Hillingdon Council
3 North, Civic Centre,
High Street,
Uxbridge,
UBS 1UW

Date: 19th December 2023
Our Ref: 26/268387
Your Ref: 2382/APP/2023/2906

RECORD OF CONSULTATION

SCOPE OF WORKS: Redevelopment of the site to create the Hillingdon Watersports Facility and Activity Centre including demolition of existing Broadwater Lake Sailing Club (BSC) clubhouse at the north of the lake and erection of a building to be occupied by HOAC and BSC including changing facilities, meeting rooms, storage, Workshop and seasonal worker accommodation (sui generis), activity shelters; installation of pontoons and concrete slipways; boat shed; equipment storage huts (north of lake and at entrance); boat parking and racking areas; camping area; outdoor activity areas; ecological enhancement throughout the site; new pedestrian routes through the peninsula; landscaping including new woodland, dense vegetation screens and boundary treatment; new access and access road; localised dredging and land reclamation; relocation of existing sailing area and creation of floating and fixed islands within the lake; coach drop off and turning area; vehicle parking; cycle parking; and associated works.

- Multi-Purpose
- Administration
- Changing/Kitchen/WC
- Accommodation
- General Store/Plant
- Circulation
- PV Panels

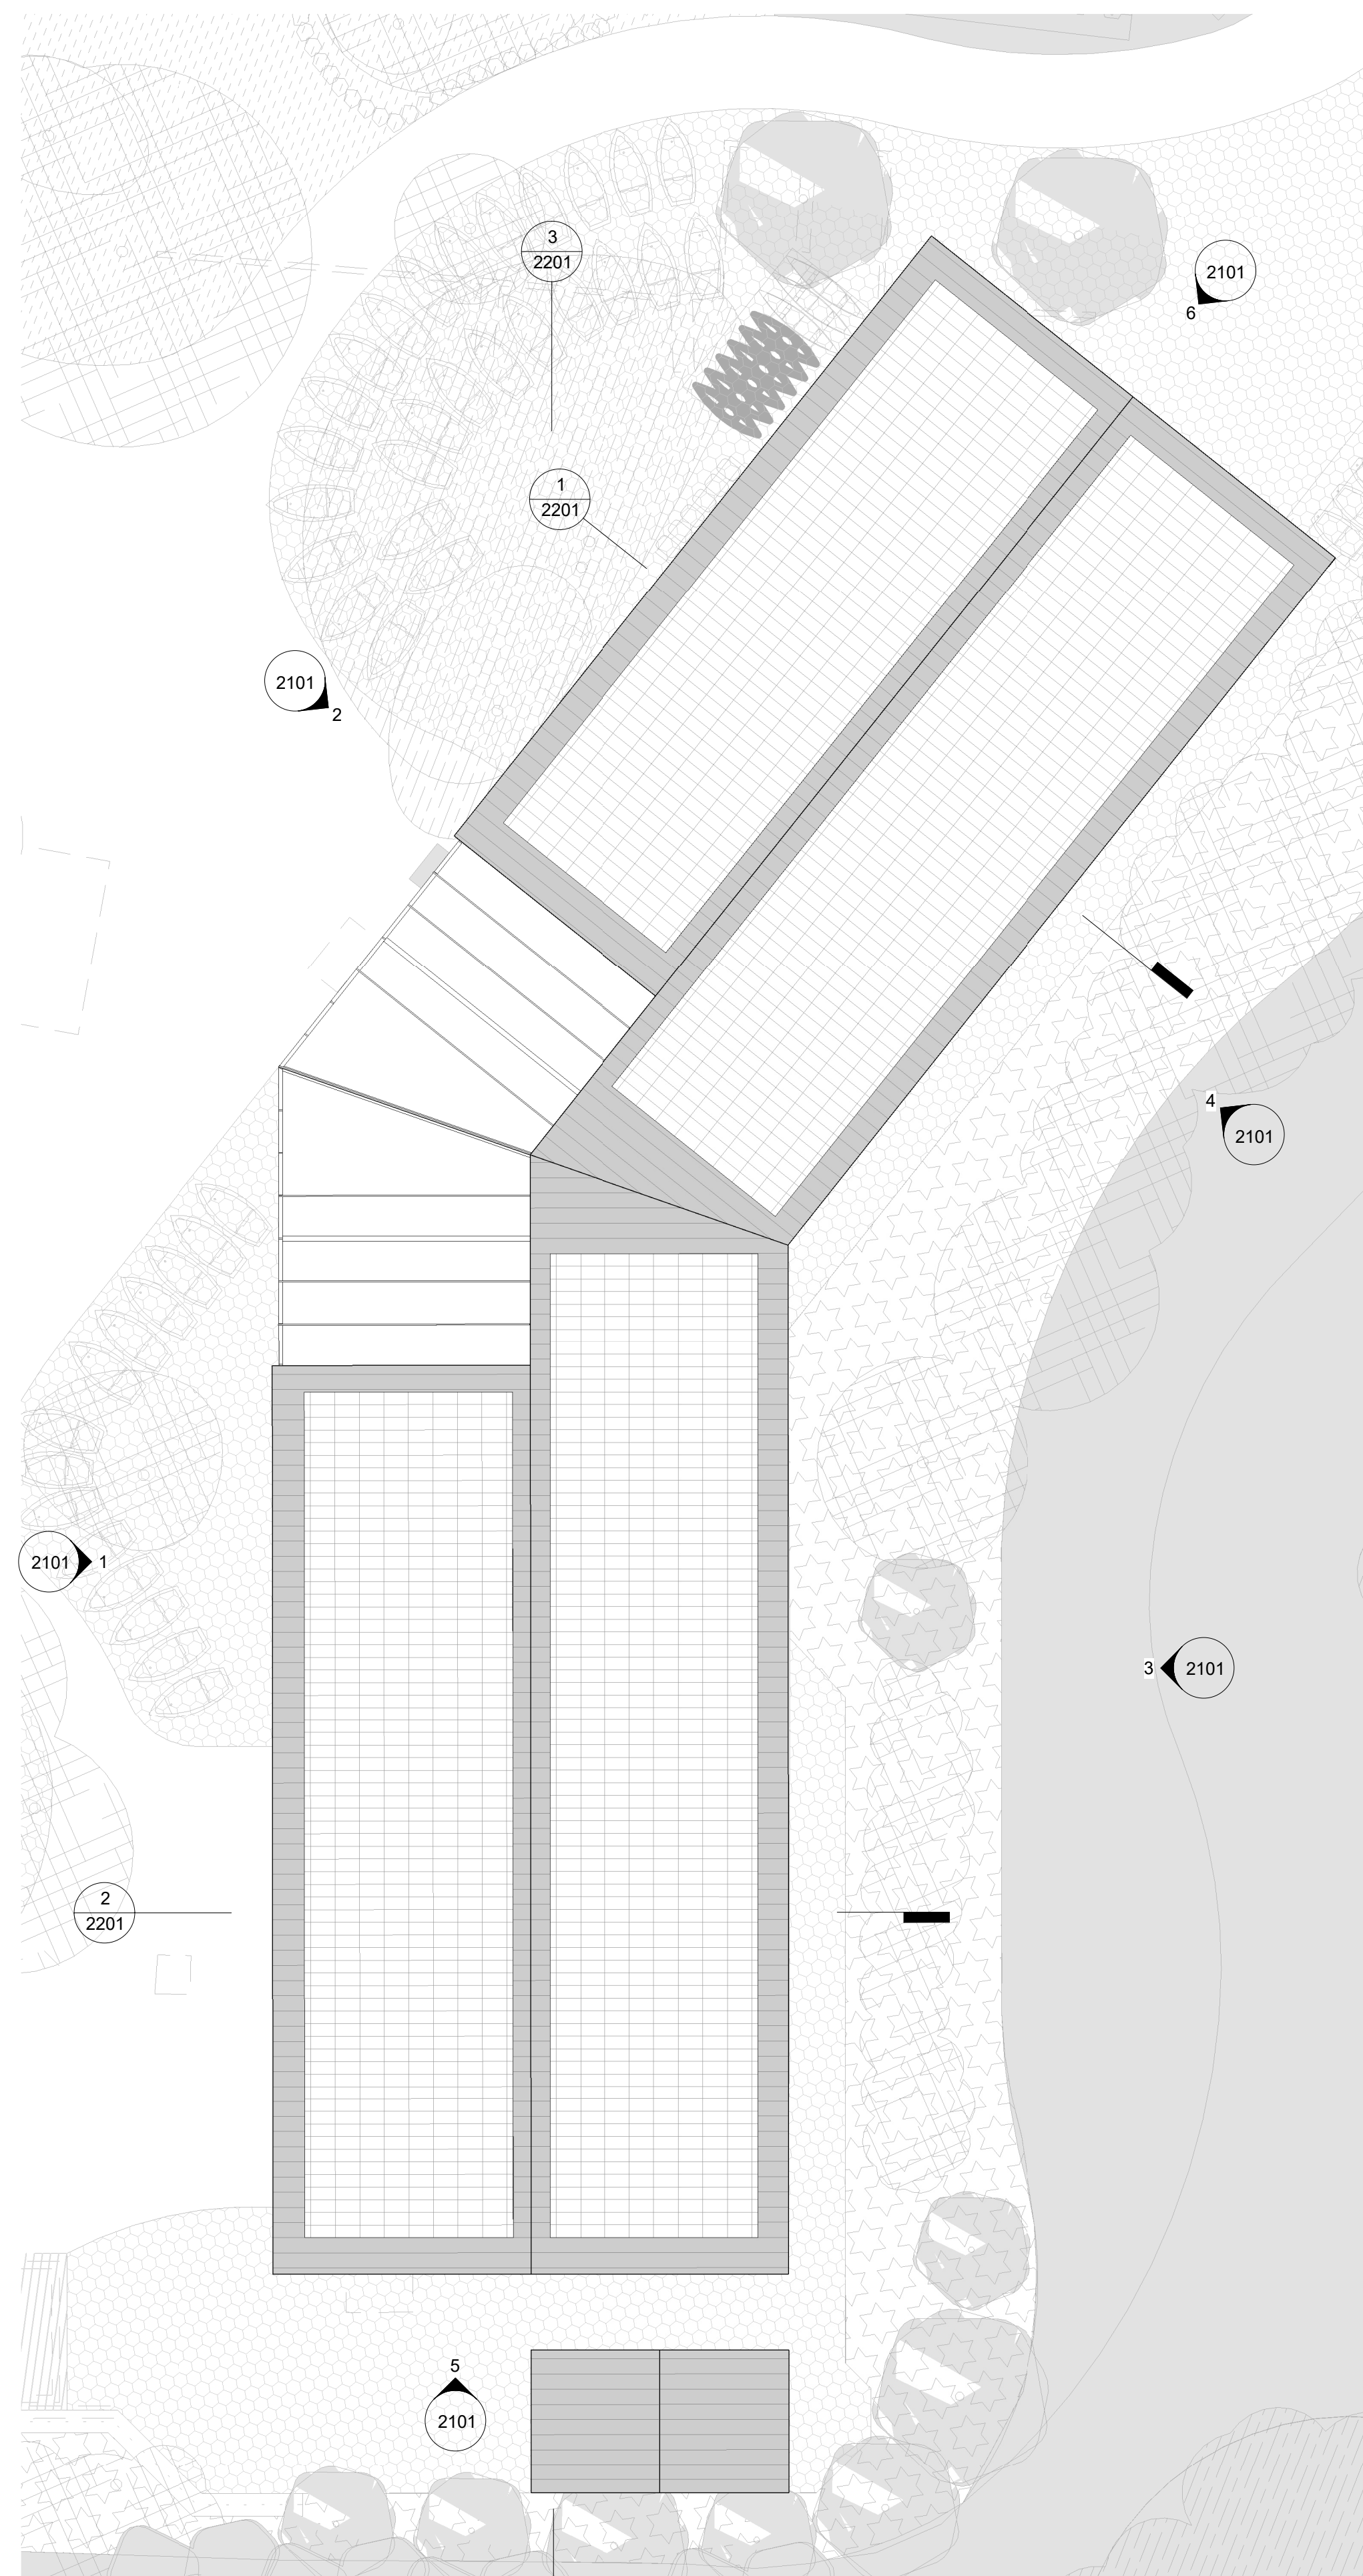
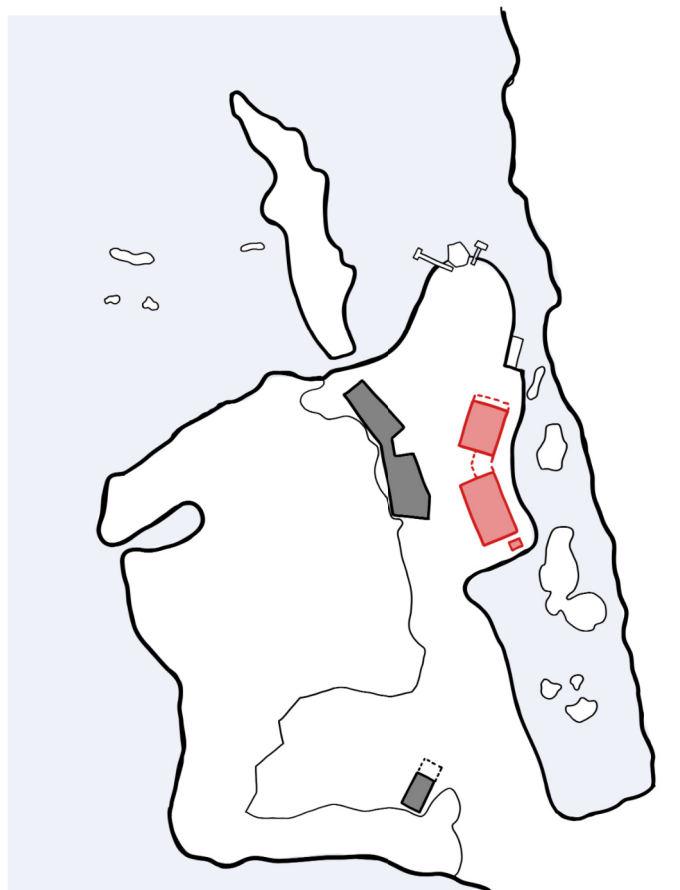
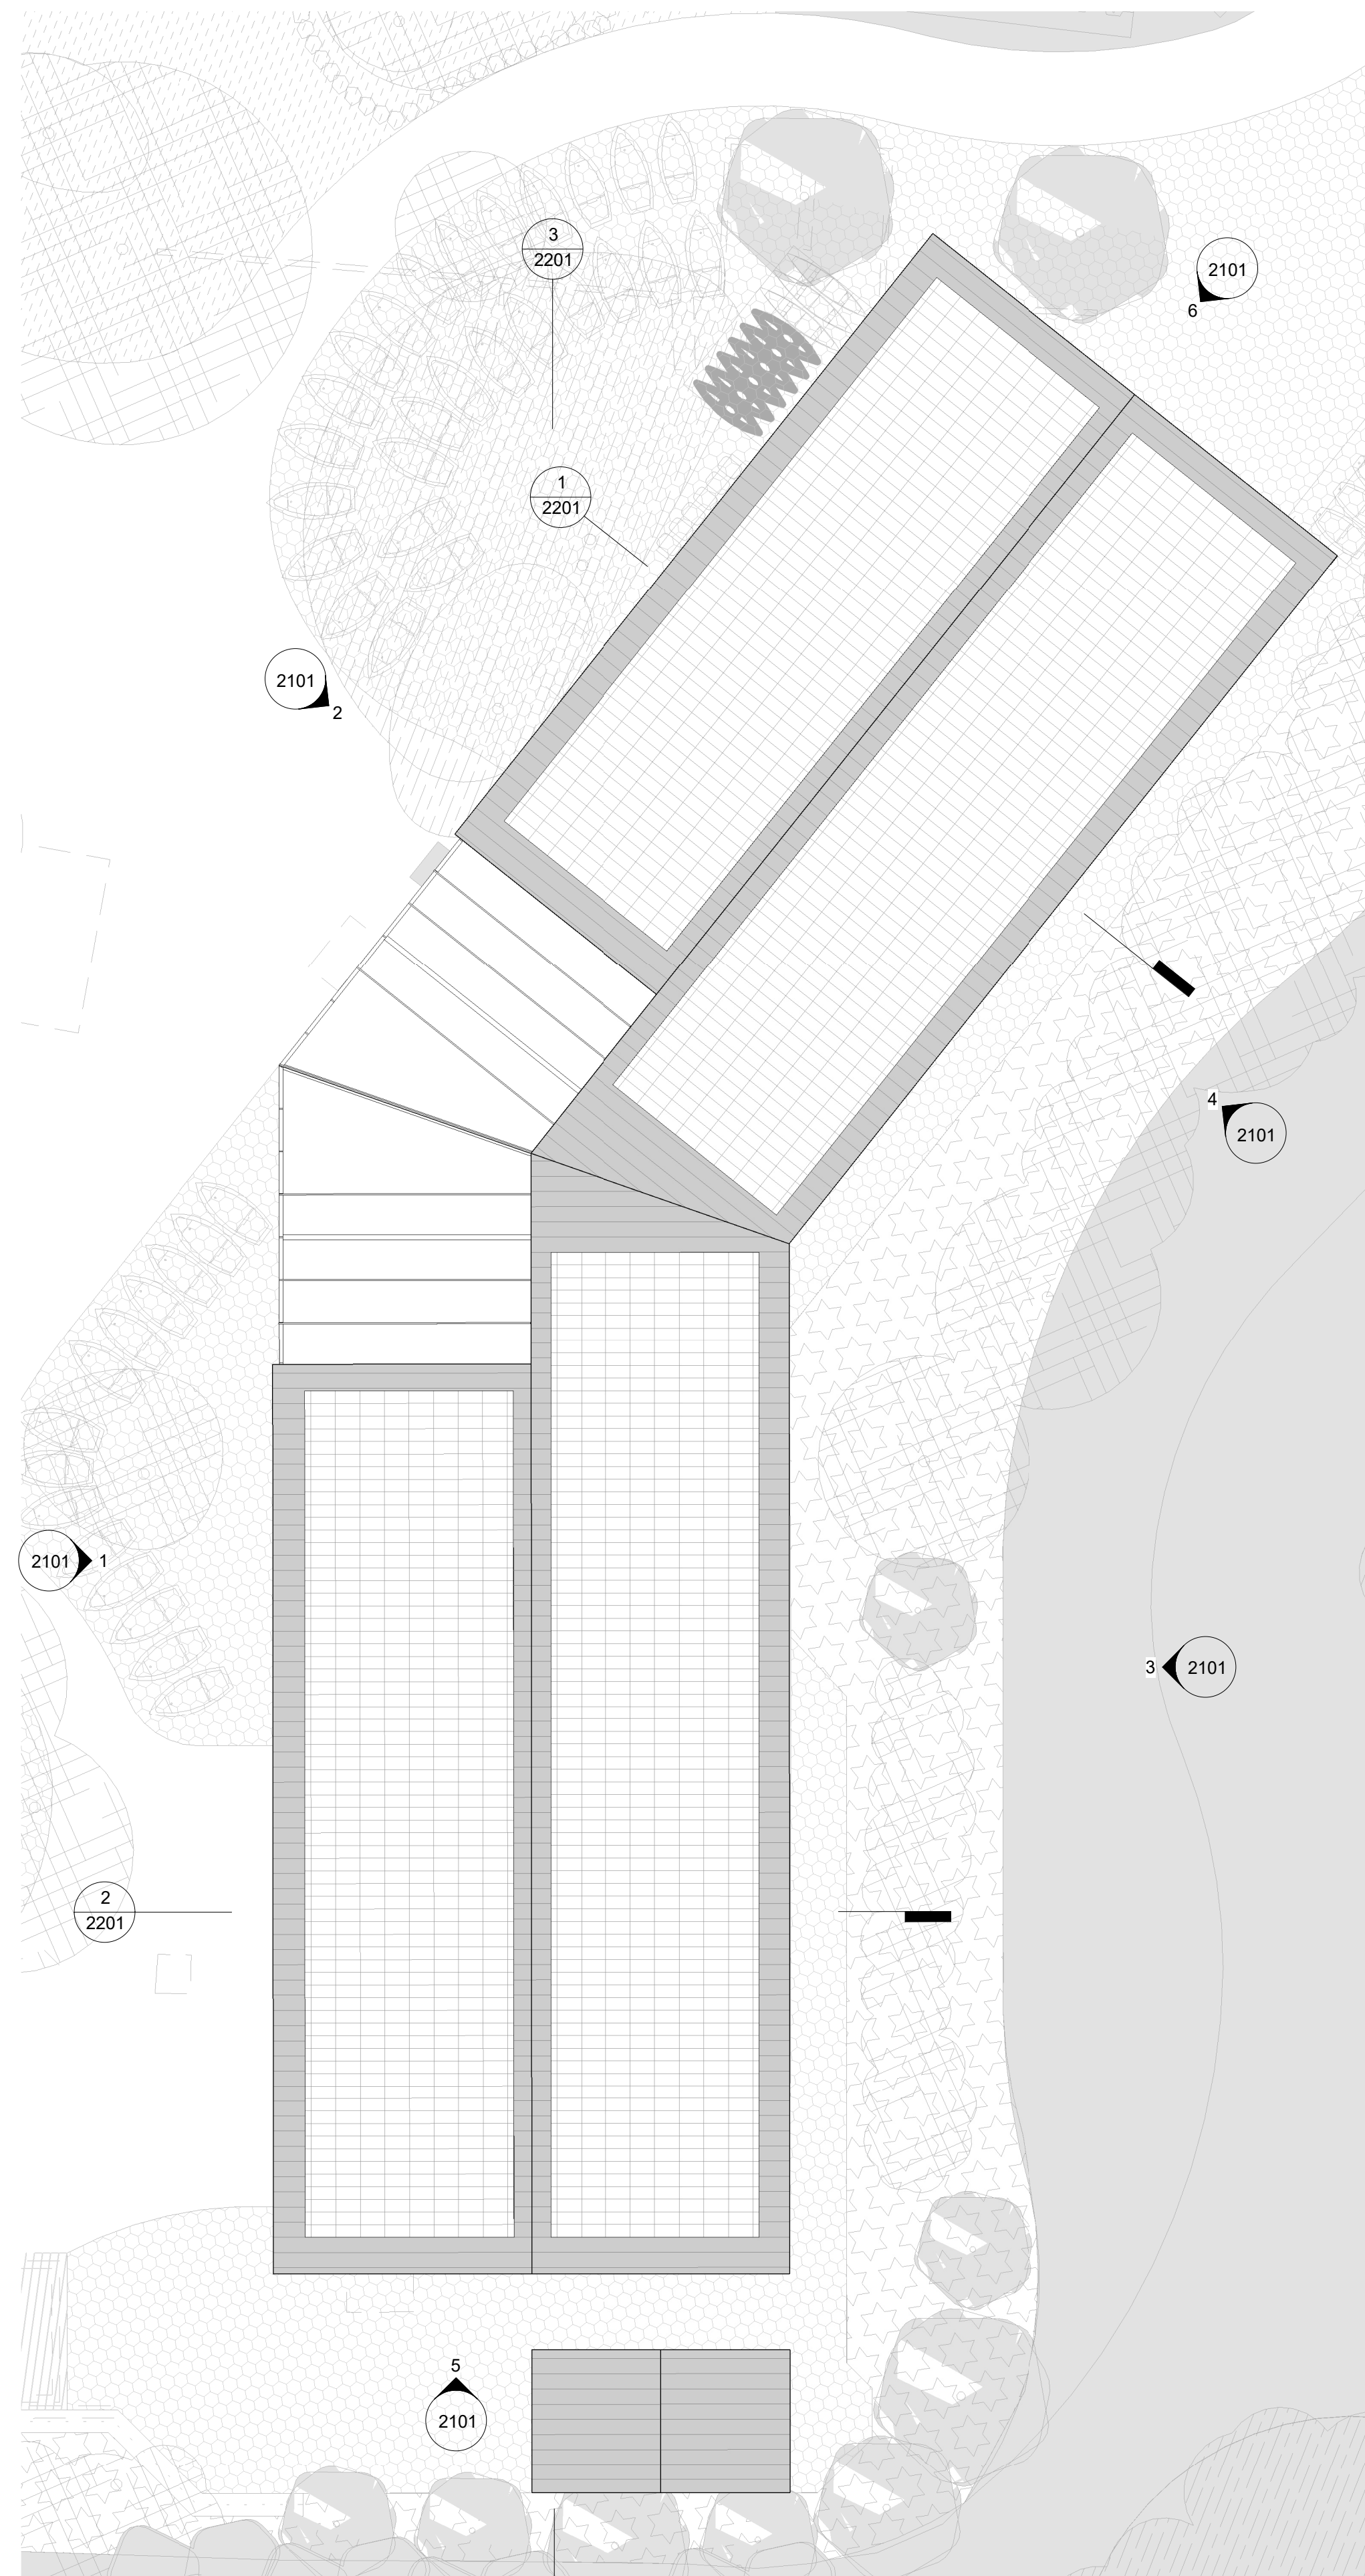
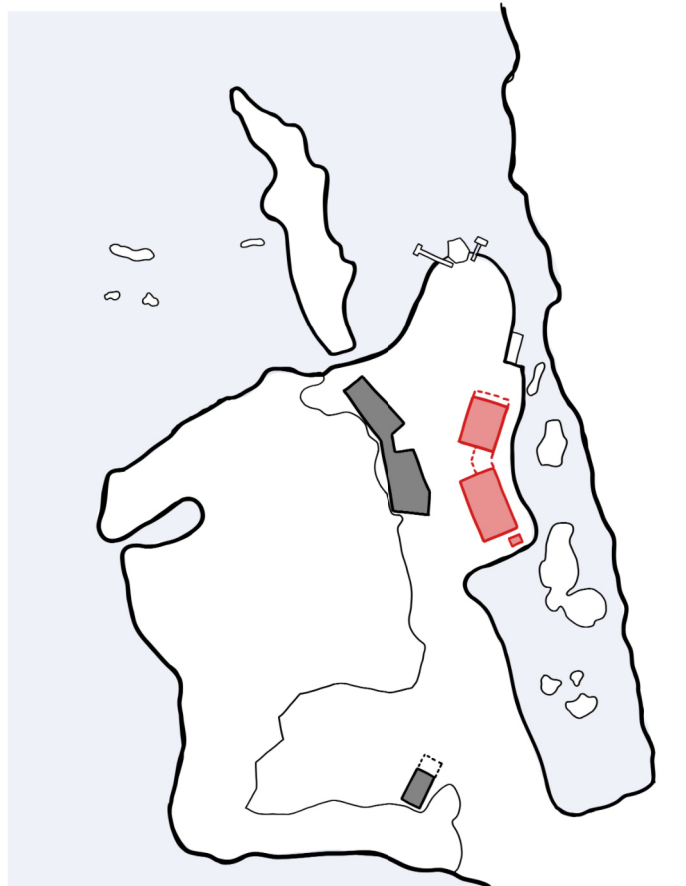
1. We note that the plans show that photovoltaic cells are proposed to be installed. Care should be taken to ensure that these are installed correctly to the manufacturer's recommendations due to concerns that have come to light in regards to the fire hazards associated with poorly fitted installations. We recommend that 'arc-fault' protection is fitted if possible, and also request that it

is clarified whether there is any access (e.g. for maintenance) to the areas where the cells are situated.

It is our expectation that suitable isolation controls will be provided for use by firefighters. These controls should be accessible to firefighters and provided with suitable local signage to identify their location. The location of isolation controls should also be shown on premises information plans provided in a Secure Information Box or equivalent operational/emergency information pack provided for fire and rescue service use, as appropriate.
